Technical Review – Surface Water  
Assessment (SSD-5765)

# TECHNICAL REVIEW - SURFACE WATER ASSESSMENT (SSD-5765)

| <b>Project:</b> | N1221_001 Bowdens Silver Surface Water Review | <b>Date:</b> | 27 July 2020 |
| <b>Subject:</b> | Surface Water Review – Technical Comments     |              |              |

Figure 7.23 - 10% (1 in 10) AEP predicted impacts on peak flood levels along Lawsons Creek in the vicinity of the proposed Lawsons Creek Crossing - Lawsons Creek Crossing Scenario

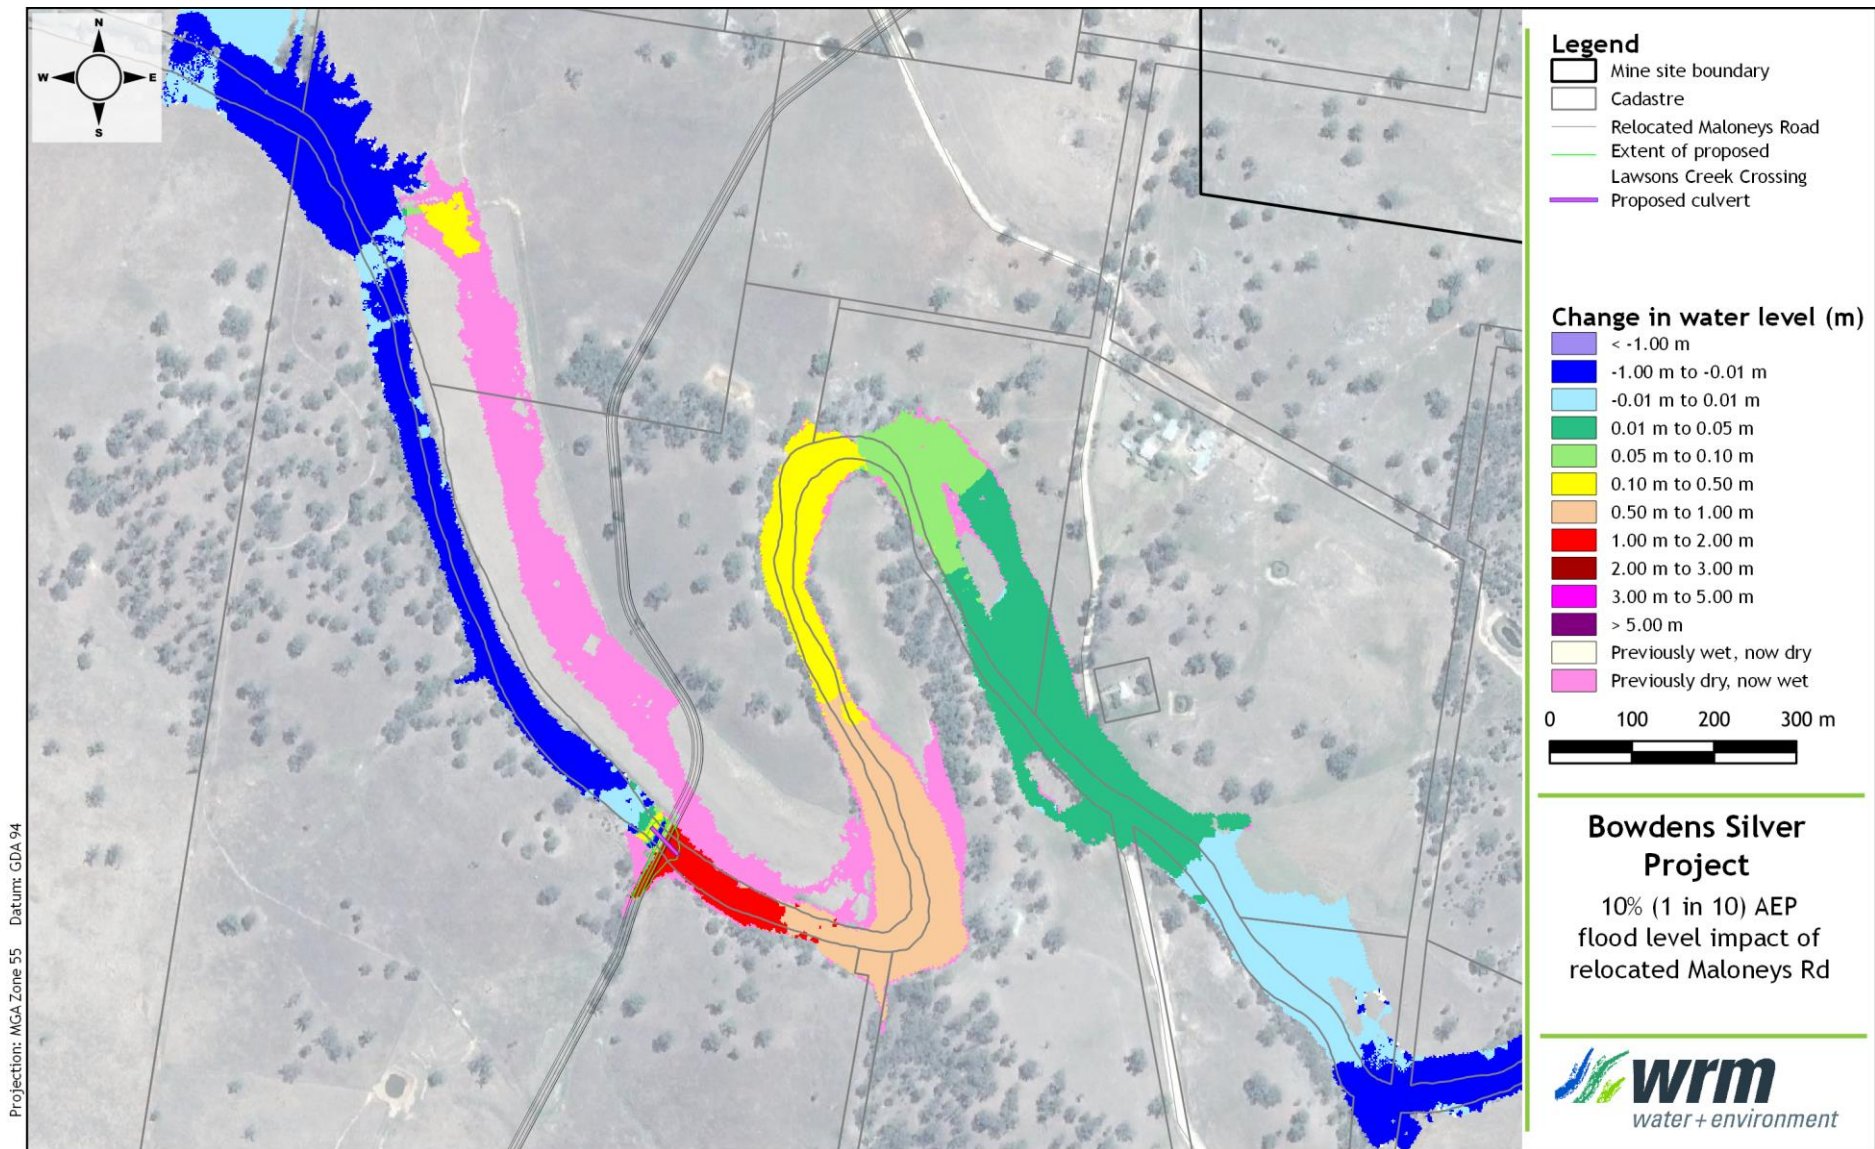
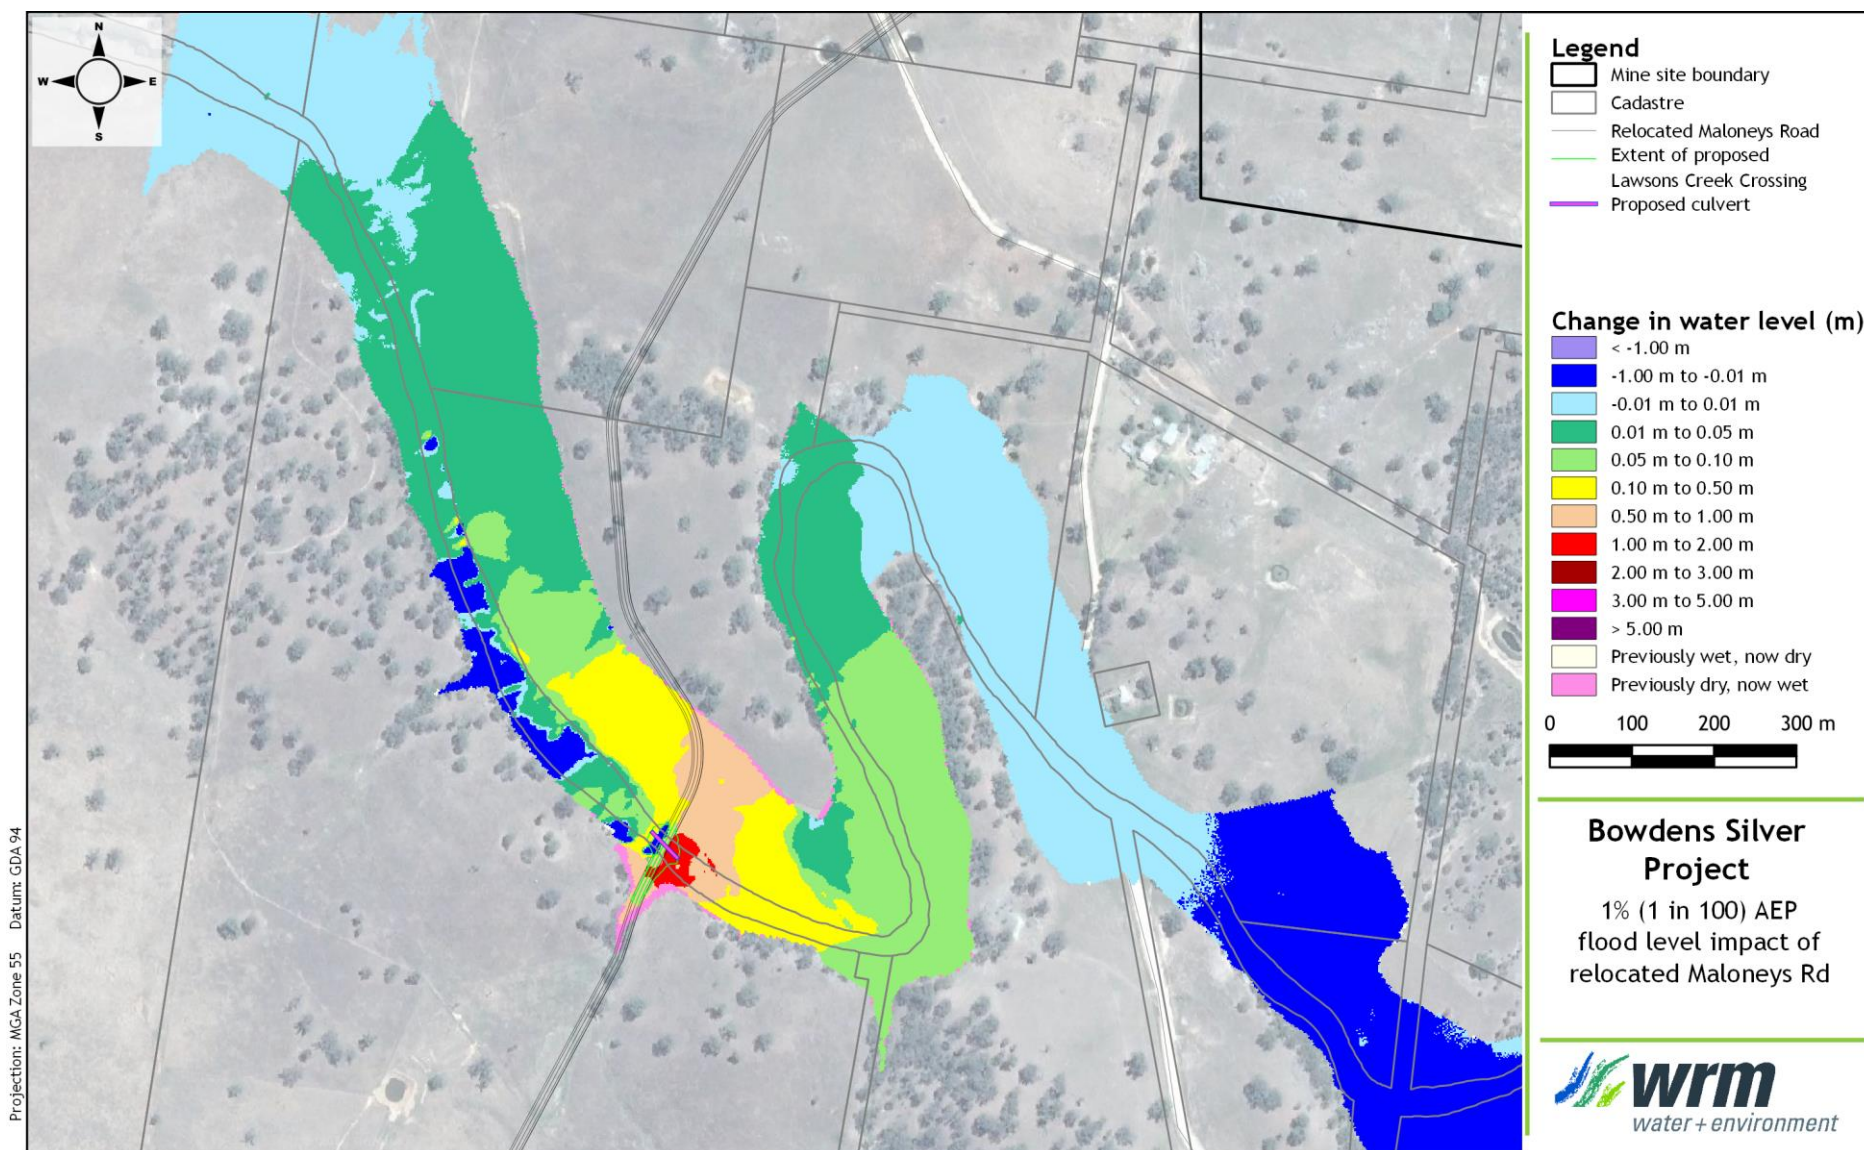
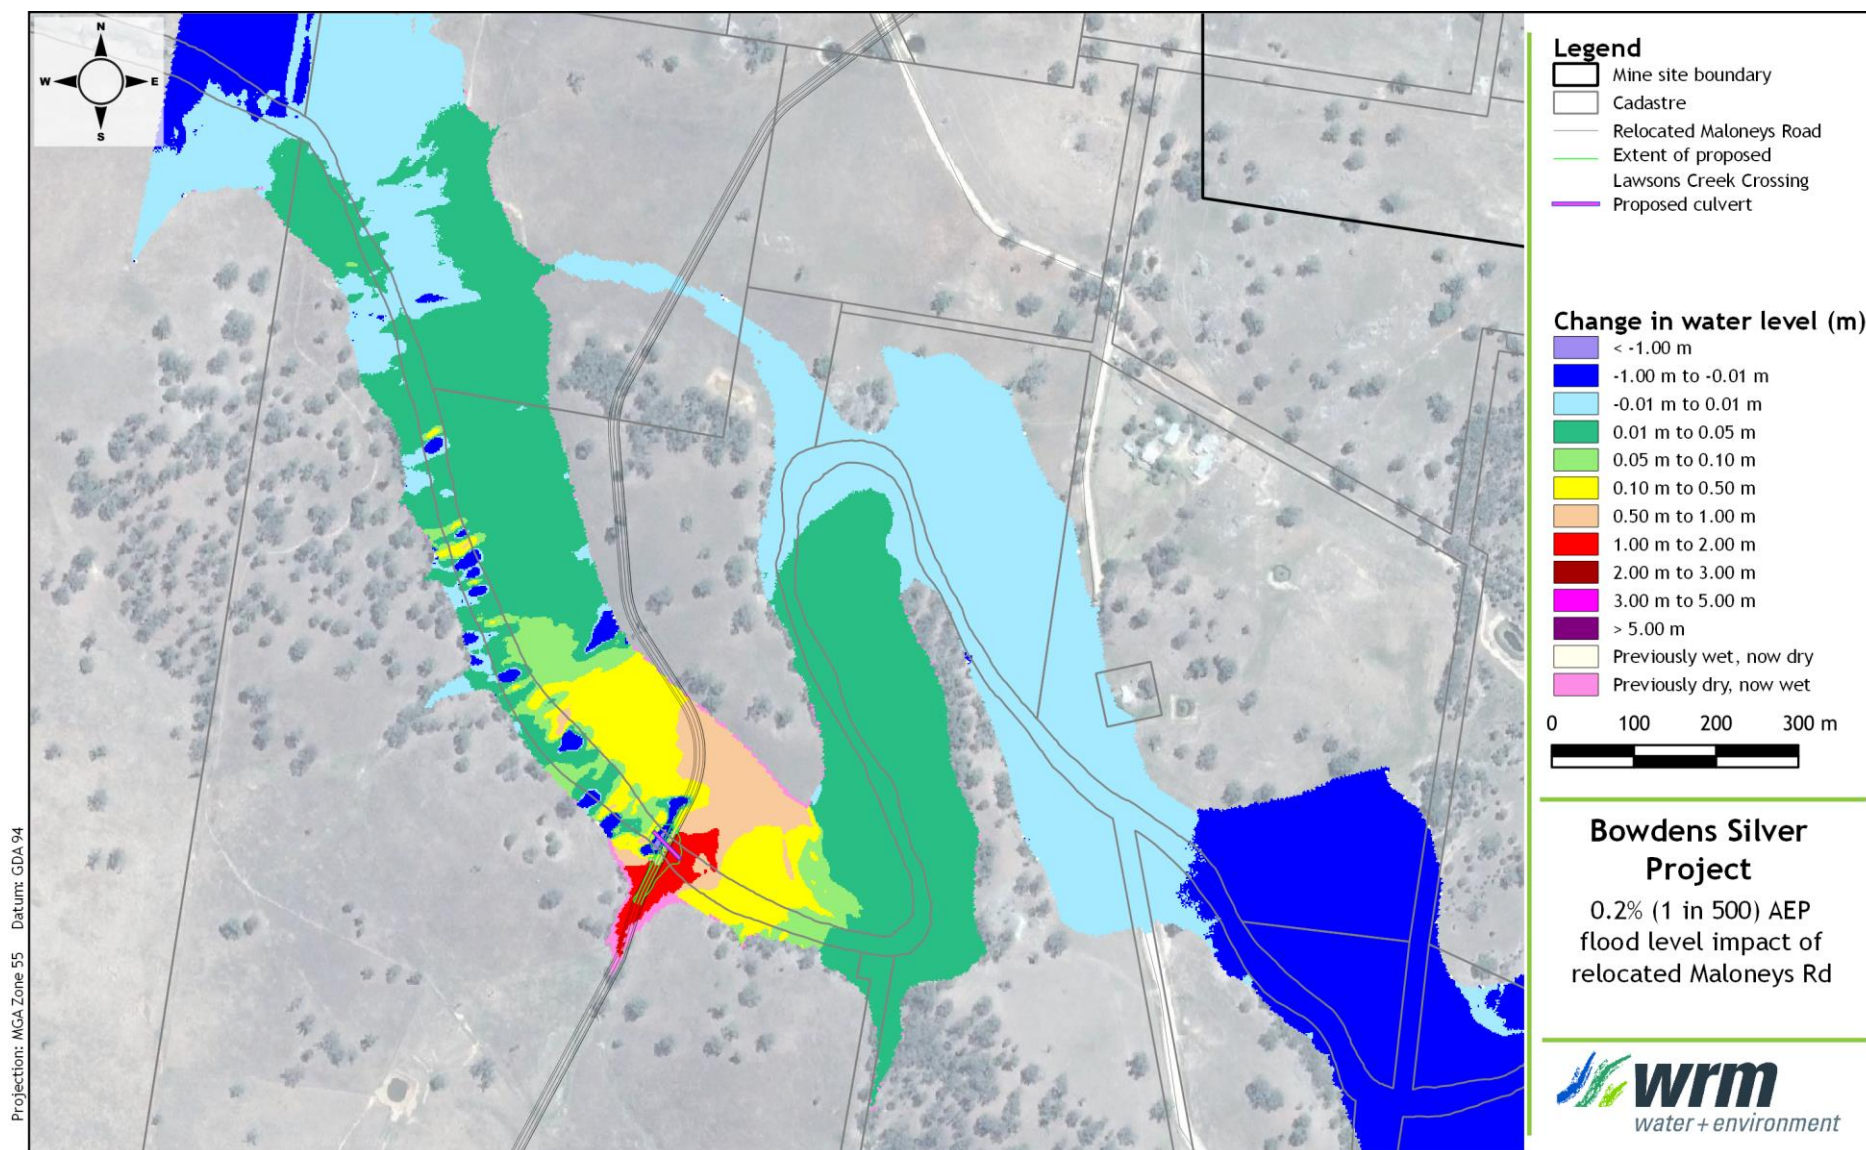
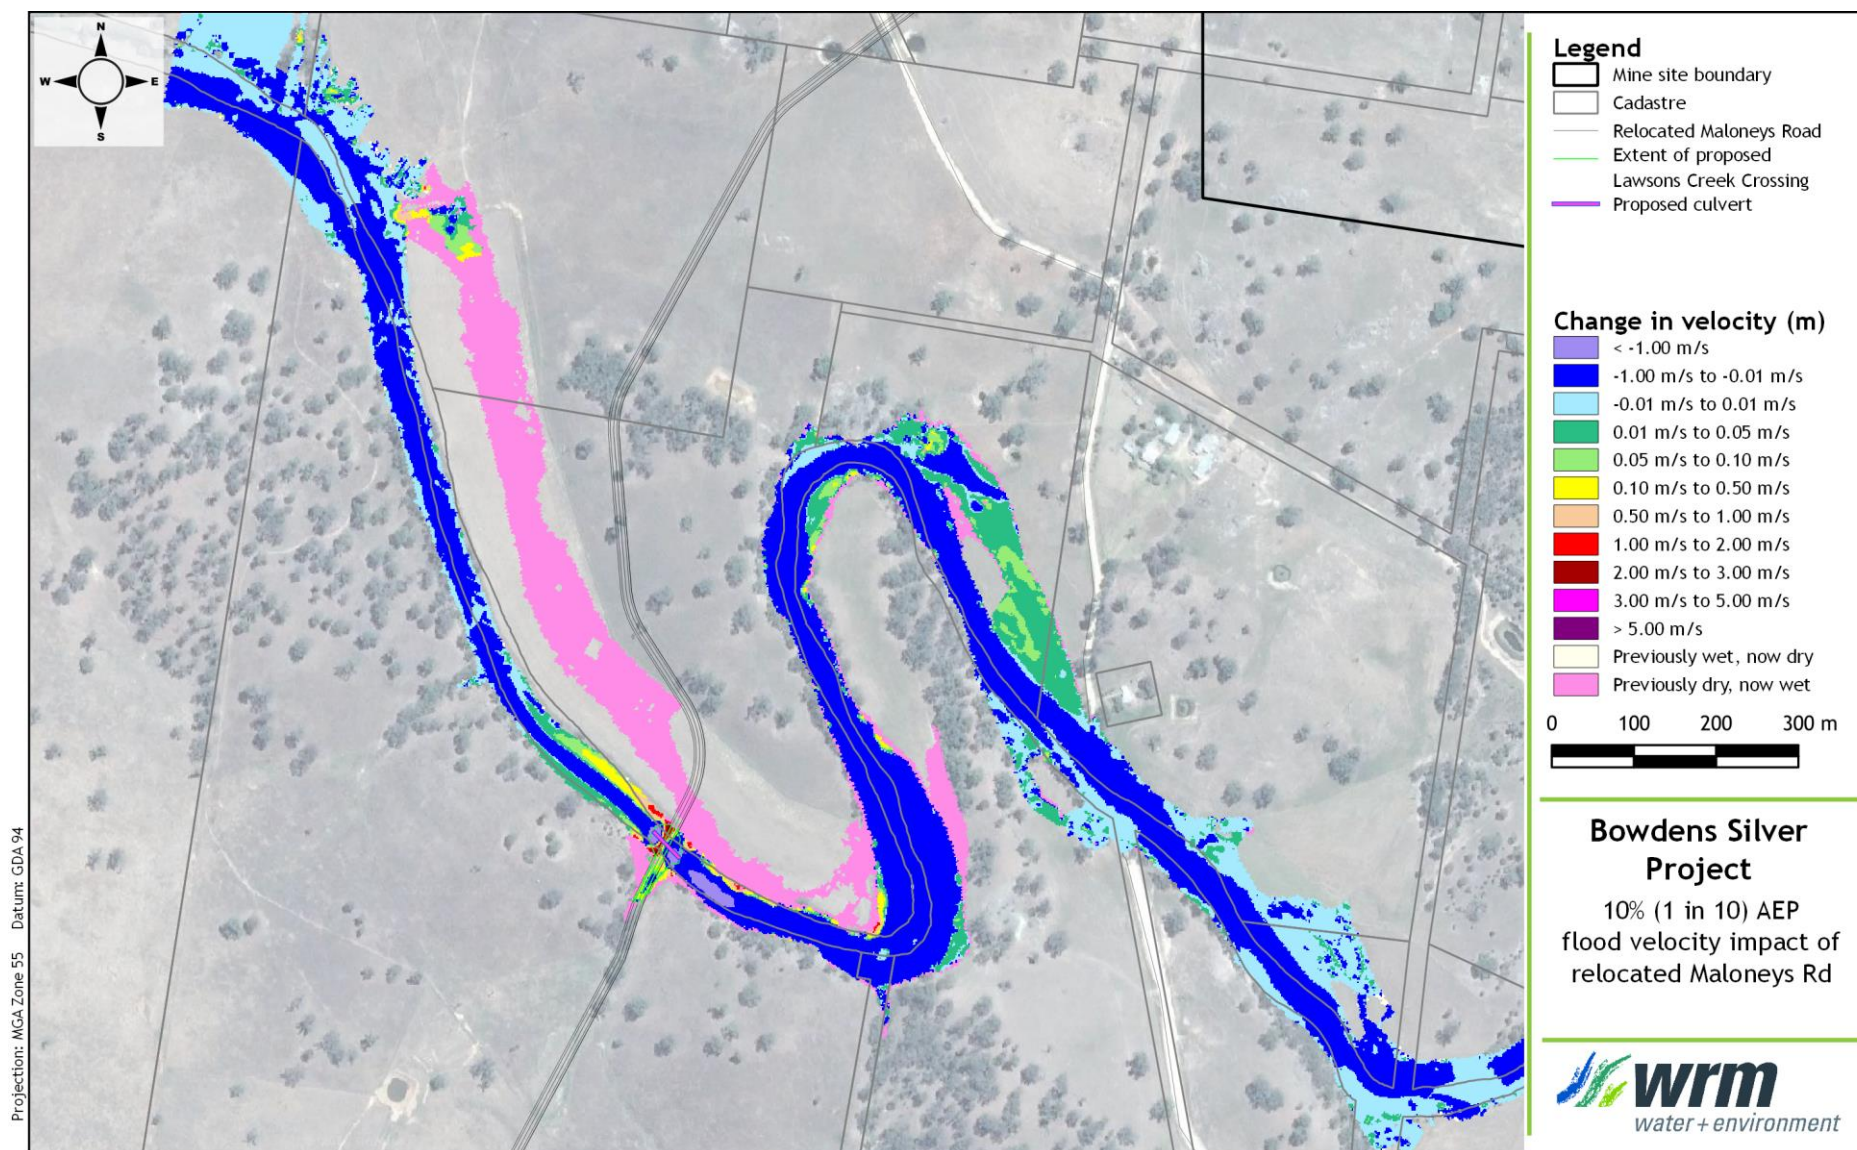
The assessment of flood risk for existing Maloneys Road crossing is not included in the assessment and as such there is no ability to compare the proposed crossing to the existing crossing. The modelling indicates that the proposed crossing will result in increases in flood depths of 1 to 2 m upstream of the new crossing in the 10% Annual Exceedance Probability (AEP) event, as well as a breakout occurring that is not present in the existing conditions. More information on the acceptability of the potential impacts of the flood risk and the breakout should be provided.

| Section  | Aspect  |
|--|---|
| Section 6 Flood Impact Assessment                      | <p>Predicted increases in depths – not clear whether this is land owned (or option to own) by Bowden Silver. Changes in flood depth upstream of new crossing and associated new downstream breakout zone have no clear comparison to the existing crossing accessibility and floodplain capability.</p> <p>Increase in velocities predicted in some locations requiring permanent stabilisation. Insufficient detail on where these are and the required stabilisation methods. Uncertain if the stabilisation can be established, considering the mobile creek systems described in Annexure A.</p> <p>These aspects need to be considered in more detailed in both the operational and post closure scenarios.</p> <p>No afflux mapping or analysis for smaller events.</p> |
